**Re: Champion Xpress Car Wash – 5307 4<sup>th</sup> St. NW  
Erosion and Sediment Control Plan  
Engineer's Stamp Date 8/23/2022 (F14E036A)**

Based upon the information provided in your submittal received on 7/8/22, the above referenced ESC Plan cannot be approved until the following comments are addressed.

James D. Hughes, P.E.  
Principal Engineer, Planning Dept.  
Development and Review Services

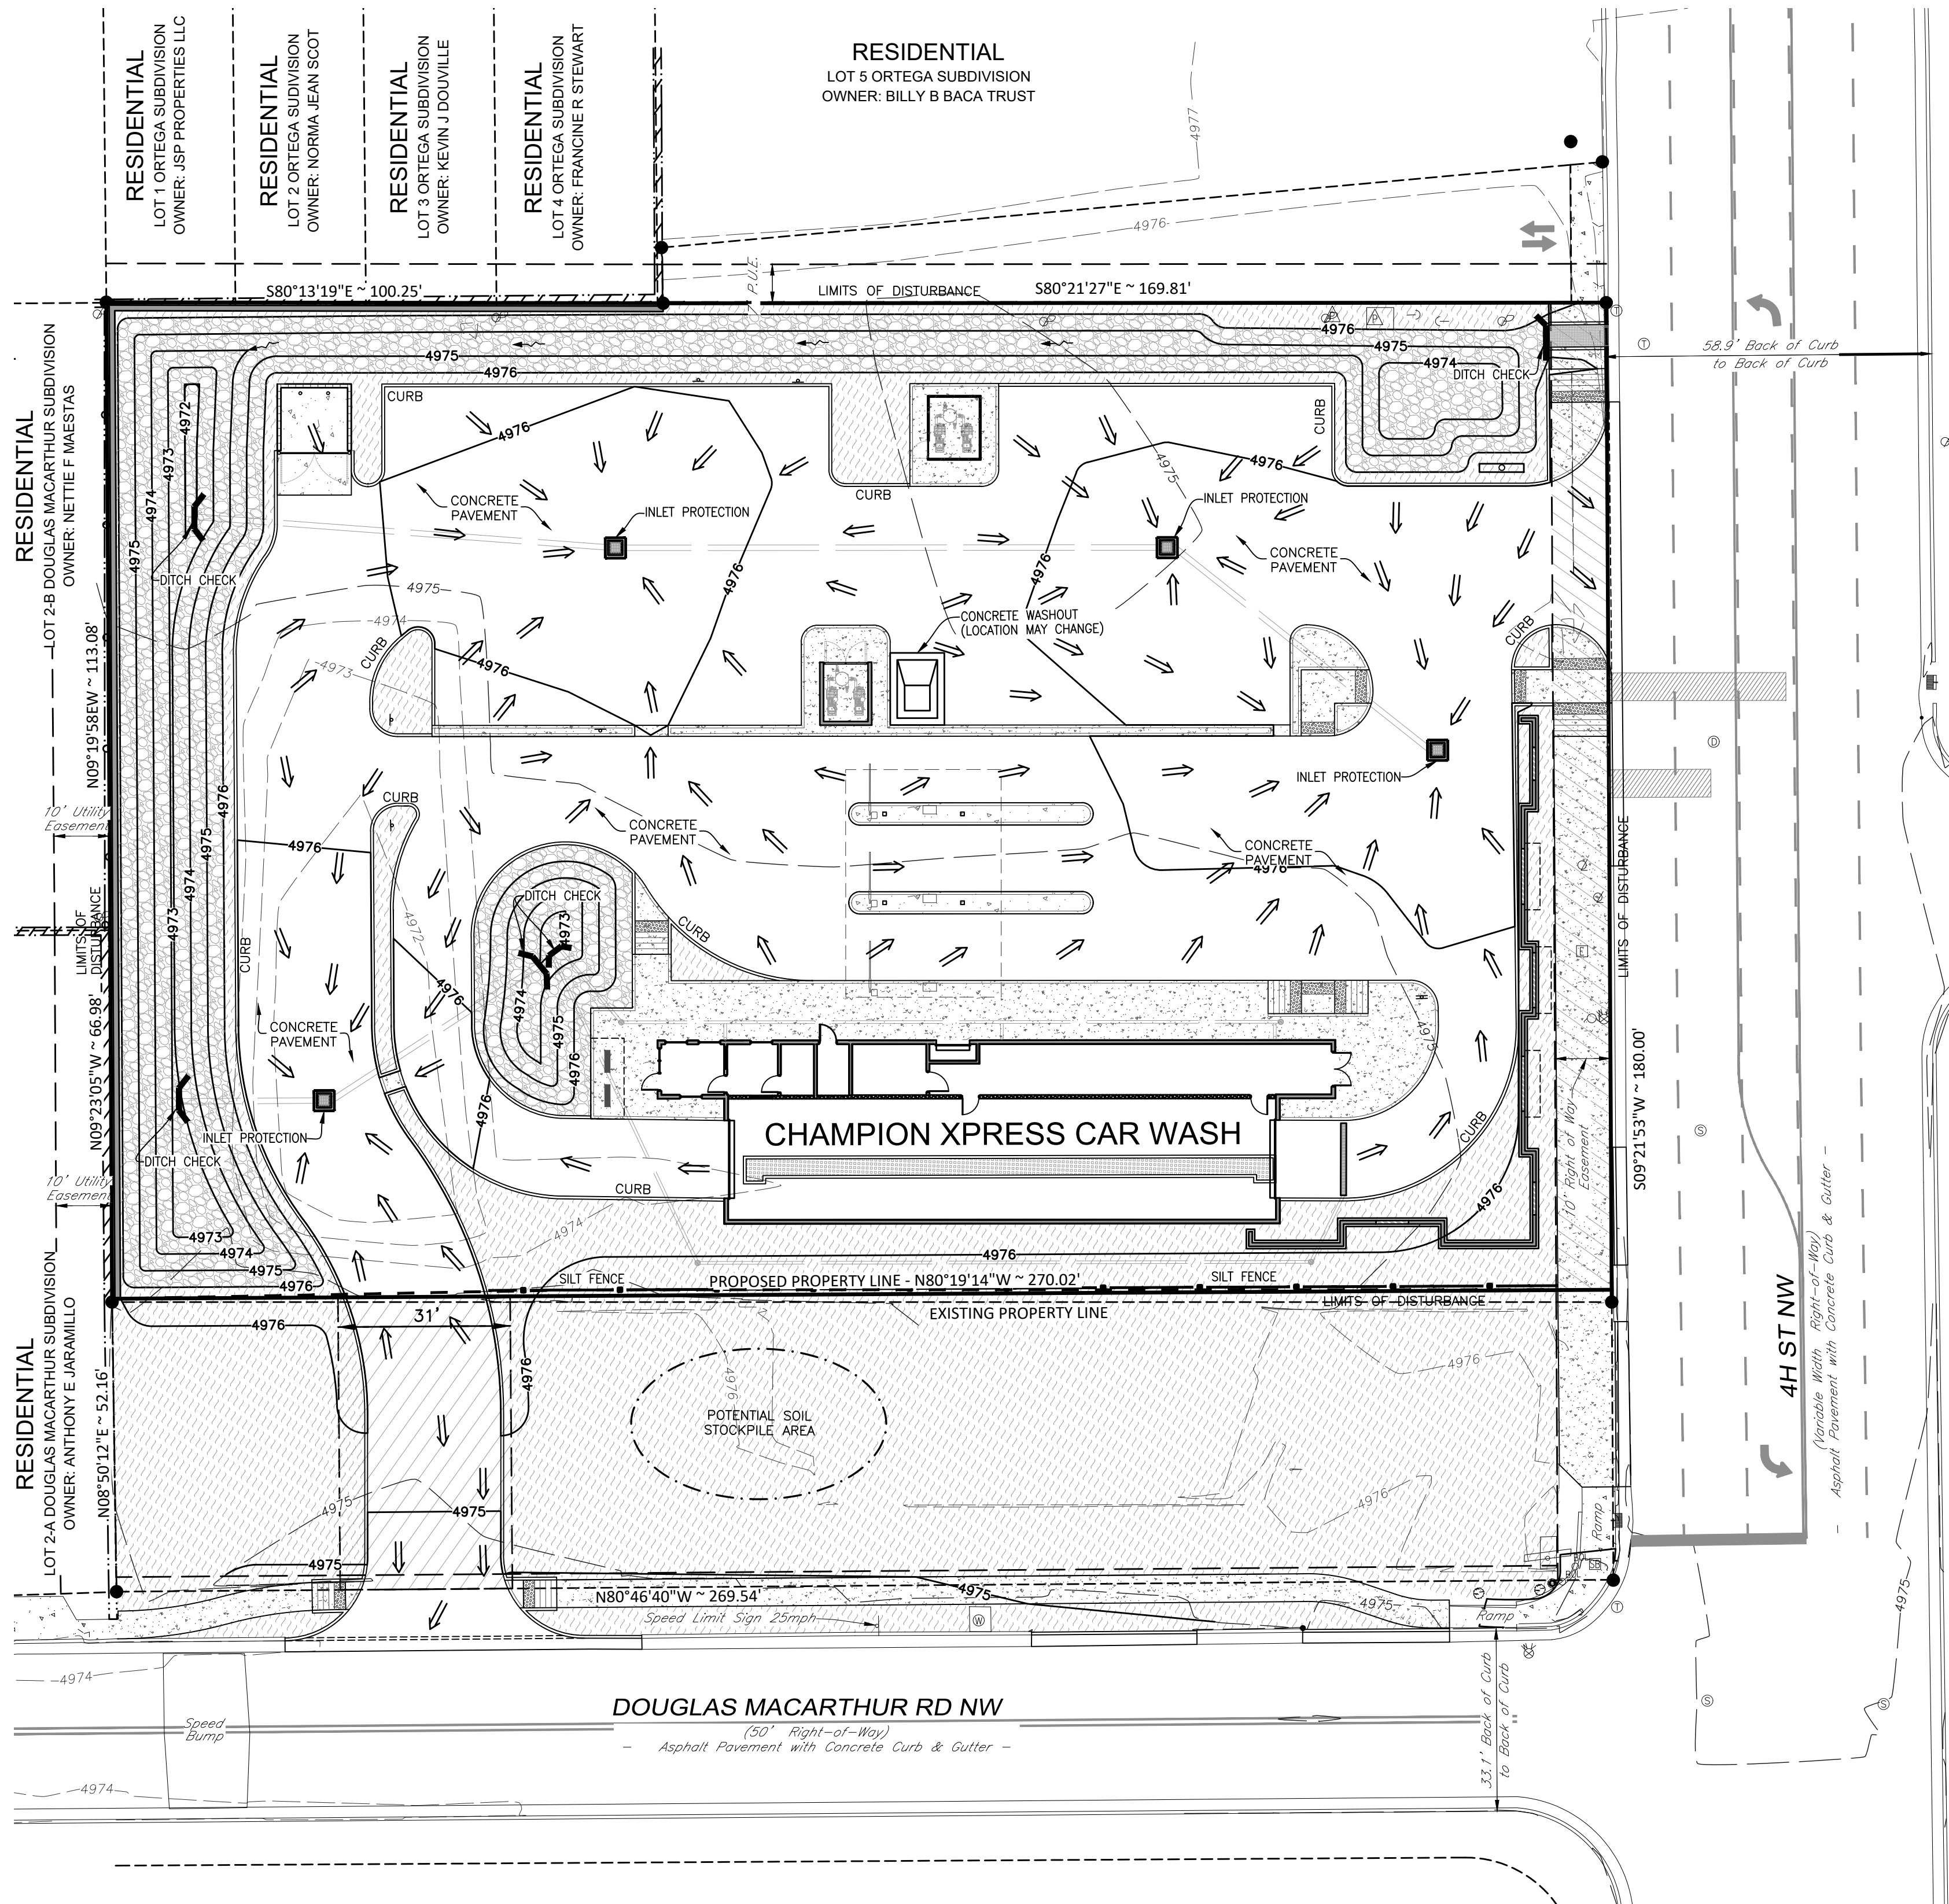
4. The Limits of Disturbance must be shown around the outer limits of all land disturbing activities, including the south lot. (CGP7.2.4.b.i)
5. Show perimeter BMPs around all areas of land disturbance and show the location of a construction entrance on the ESC Plan.
